DECISION DELEGATED TO HEAD OF PLANNING

Application No: H09-0339-26 **Applicant:** Lotus Sun Property Ltd

Proposal: Change of use from an MOT testing station, vehicle repair garage and petrol filling station to a flexible (Class Sui generis) commercial unit, while retaining the petrol filling station use

Location: 36 West End Holbeach Spalding

Delivery Service Plan

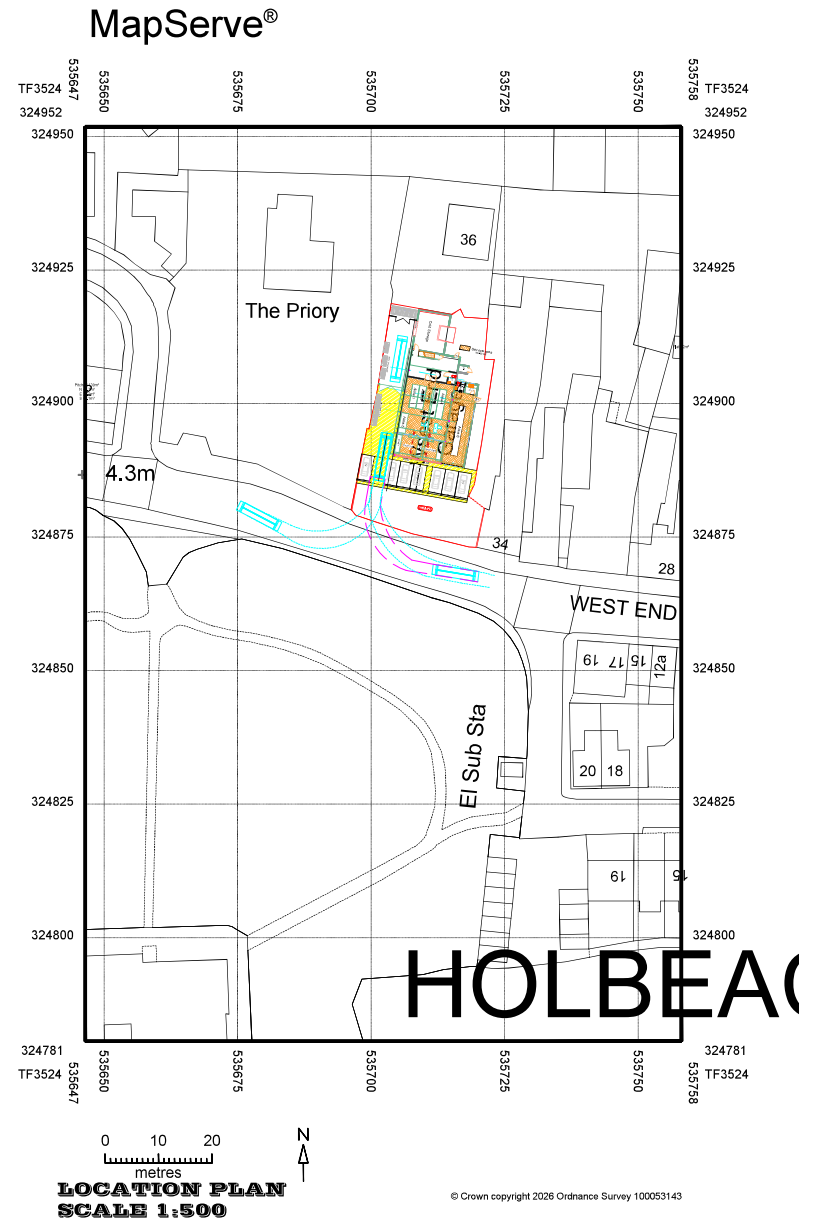
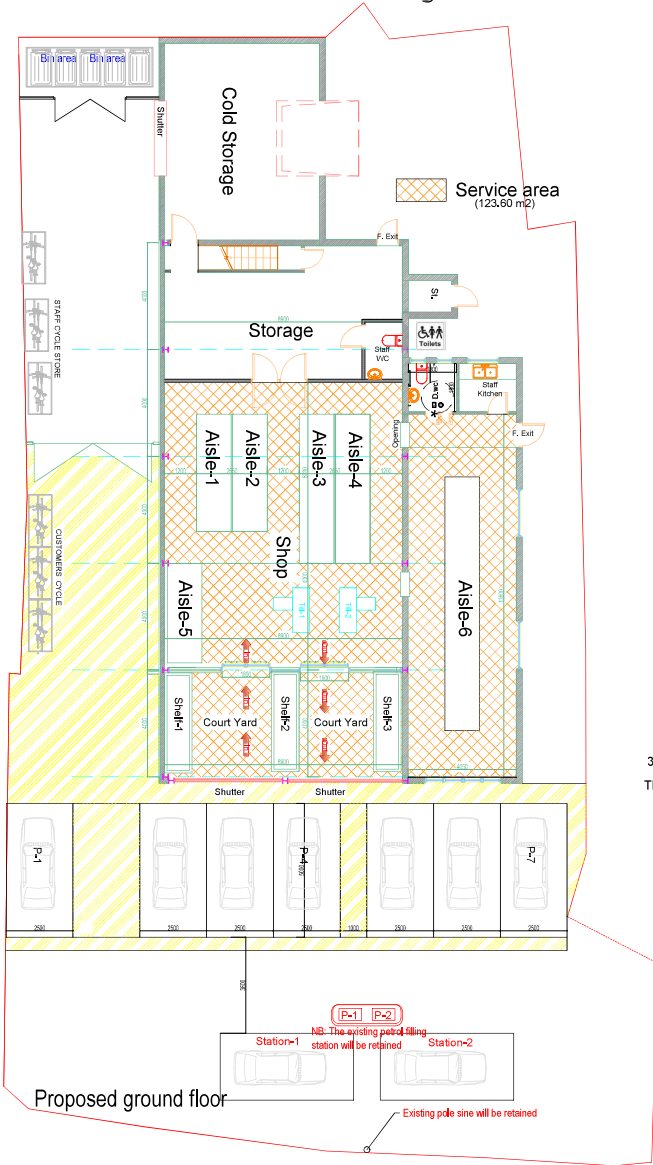
A servicing drawing is outstanding - how will delivery vehicles access and turn within the site when parking spaces are in use? A Delivery Management plan required.

The proposal relates to the change of use of part of the existing building to form a convenience store with a gross floor area of approximately 124 m². Deliveries will be limited to approximately two deliveries per week from the wholesale supplier, Booker. The servicing demonstrated is acceptable, and parking (option 5) is acceptable. Visitors to the shop will either be already on the site using the Petrol pumps or call in the shop for convenience. Either way they will be quick visits of no more than 10 minutes at a time. It is a Village location with only 2 petrol pumps on site the change of use will not create an unacceptable impact on the public highway. LCC Highways were consulted and confirmed there are no objections.
